DEVELOPMENT REVIEW BOARD
TRANSPORTATION DEVELOPMENT

DRB Project Number: 1011527
Campo Del Norte

SUBJECT: Preliminary Plat, Site Plan for Building Permit, Sidewalk Deferral, Sidewalk Waiver, Design Variance, Vacation Of Public Easement

Project Name: Campo del Norte Subdivision

**SITE DEVELOPMENT PLAN FOR
BUILDING PERMIT & SUBDIVISION
CAMPO DEL NORTE
LOTS 1-34 AND TRACTS A-E
WITHIN ELENA GALLEGOS LAND GRANT
IN PROJECTED SECTION 17,
TOWNSHIP 11 NORTH, RANGE 4 EAST
NEW MEXICO PRINCIPAL MERIDIAN
CITY OF ALBUQUERQUE
BERNALILLO COUNTY, NEW MEXICO
MAY 2018**

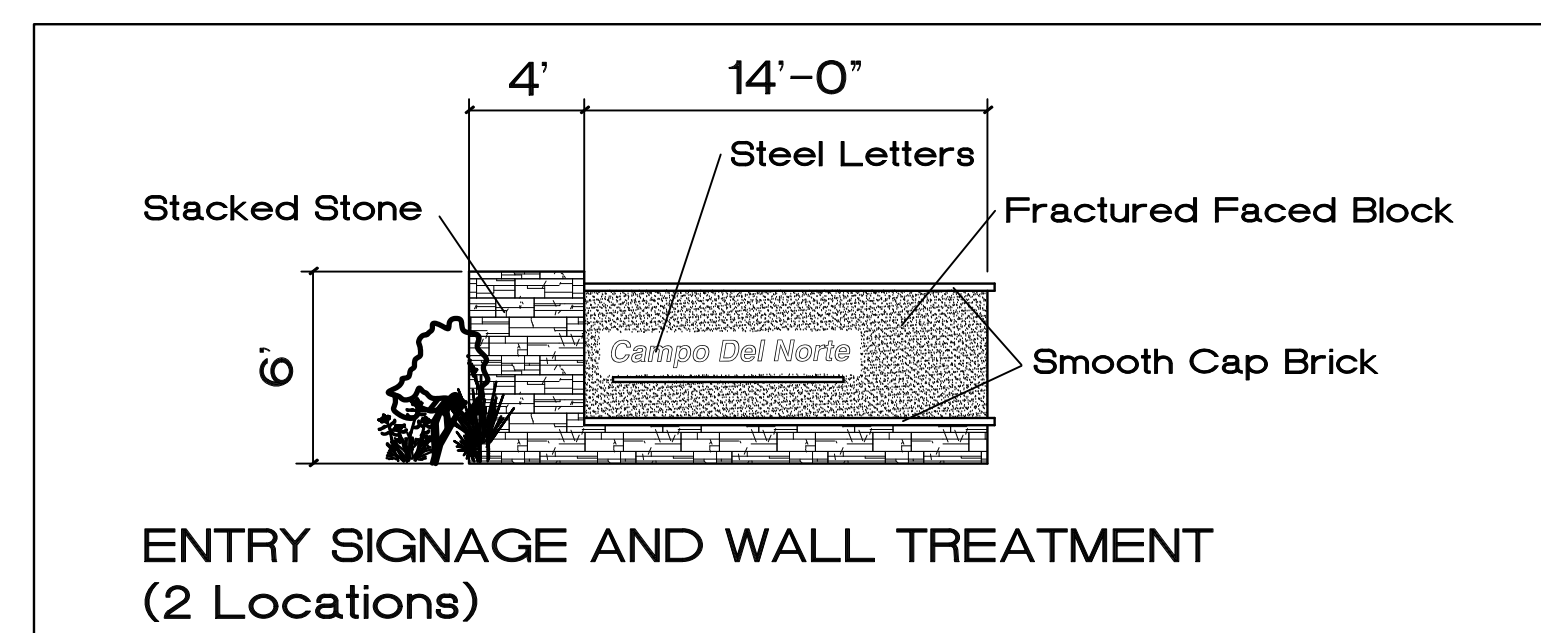
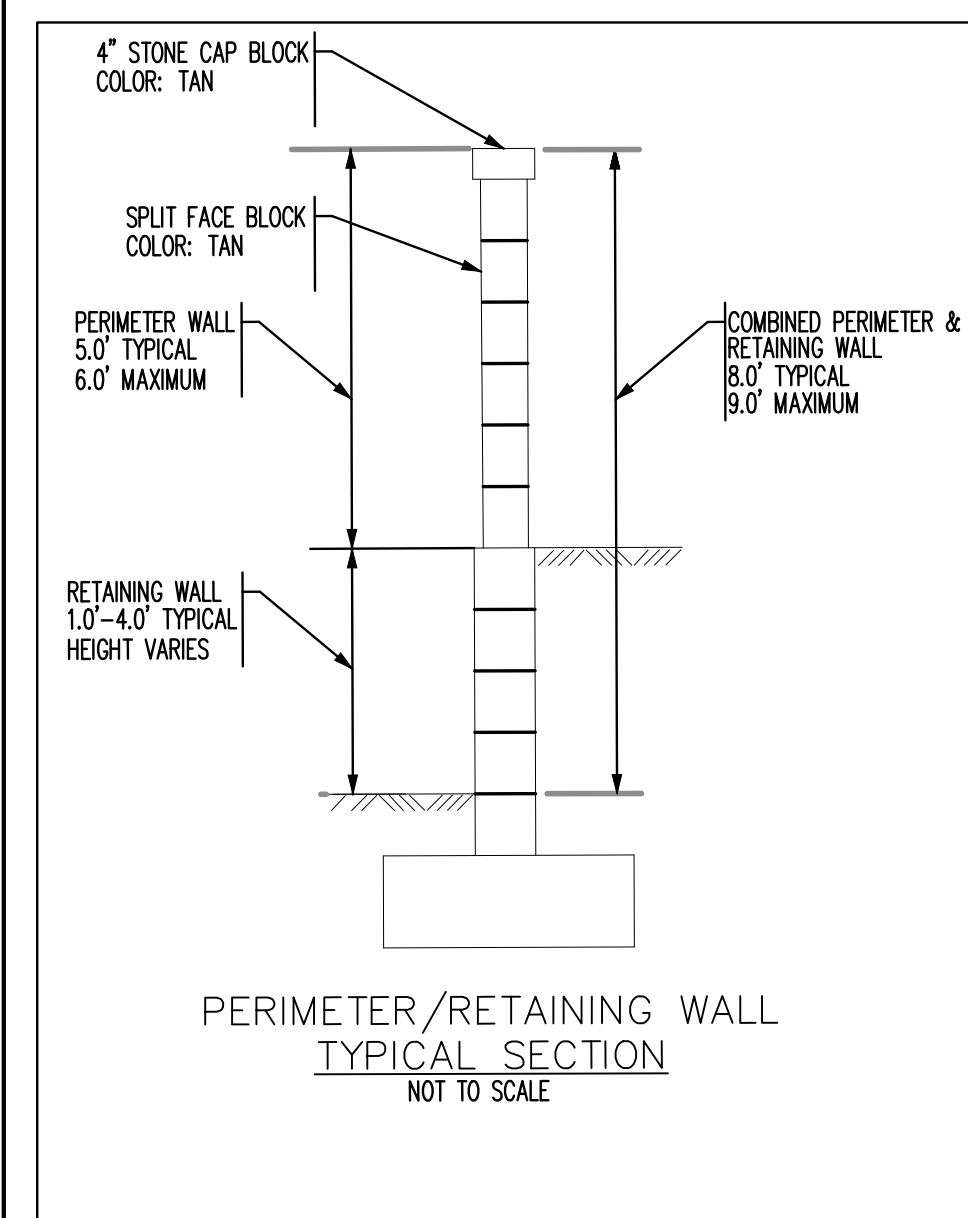
1. Provide an exhibit showing the cross section of the proposed roads.
2. Infrastructure along Alameda needs to be included on the infrastructure list.
 - a. 12' Pavement
 - b. 6' Sidewalk
 - c. Bike lane markings
